Our Case Number: ACP-323980-25

Re: Proposed Water Supply Project for the Eastern and Midlands Region
in the counties of Clare, Limerick, Tipperary, Offaly, Kildare, and Dublin.

The Local Authority Waters Programme Submission to An Coimisiún Pleanála – Case 323980 - Water Supply Project for the Eastern and Midlands Region

Drawing Title: Figure 4.62 RAW WATER INTAKE AND PUMPING STATION AT PARTEEN BASIN ACCESS ROAD

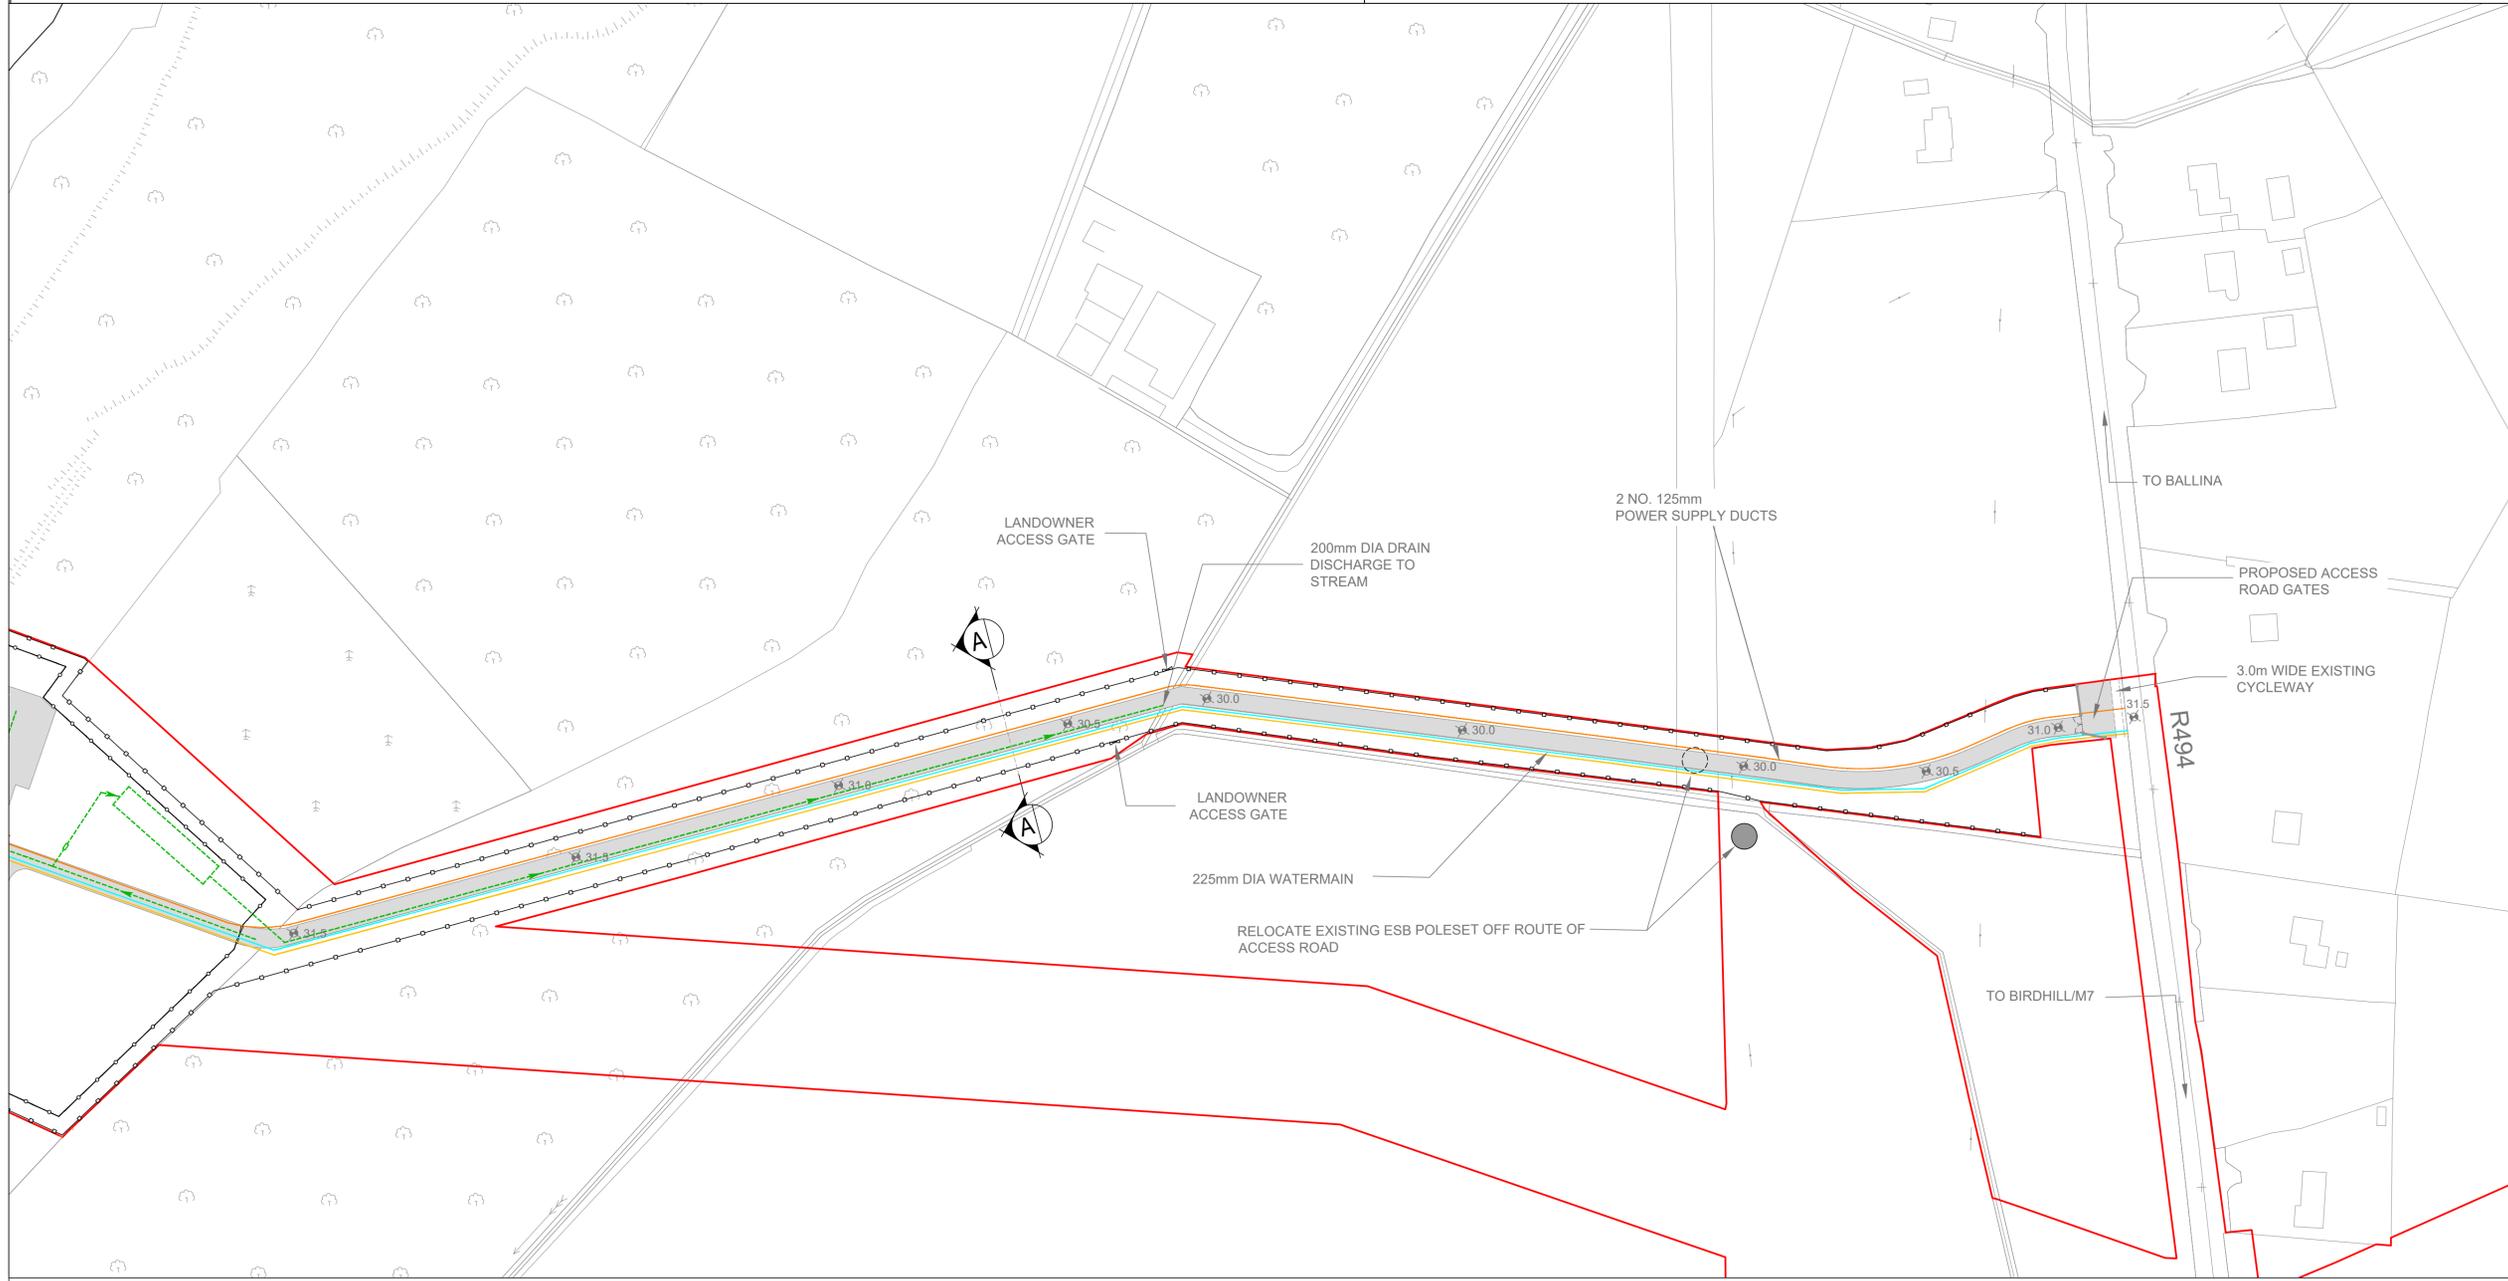
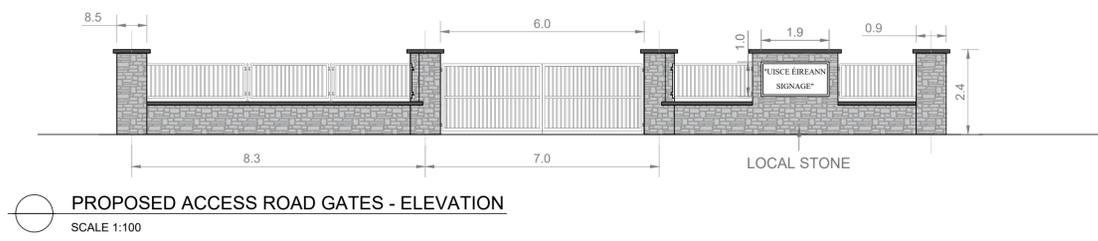
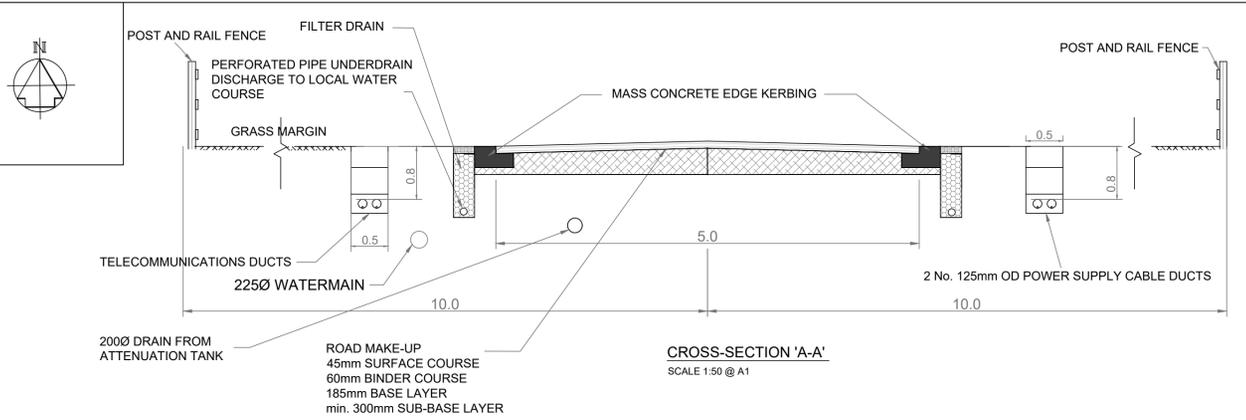
The depth of pipe at the abstraction point was not clear in the documents provided which is an important consideration that can potentially impact the ecology and temperature of the lake if taken at an incorrect level. This could have the effect of abstracting cooler water if at lower depth which in turn could impact on the overall temperature dynamics and potentially contribute to pressure on the ecosystem, particularly during the summer.
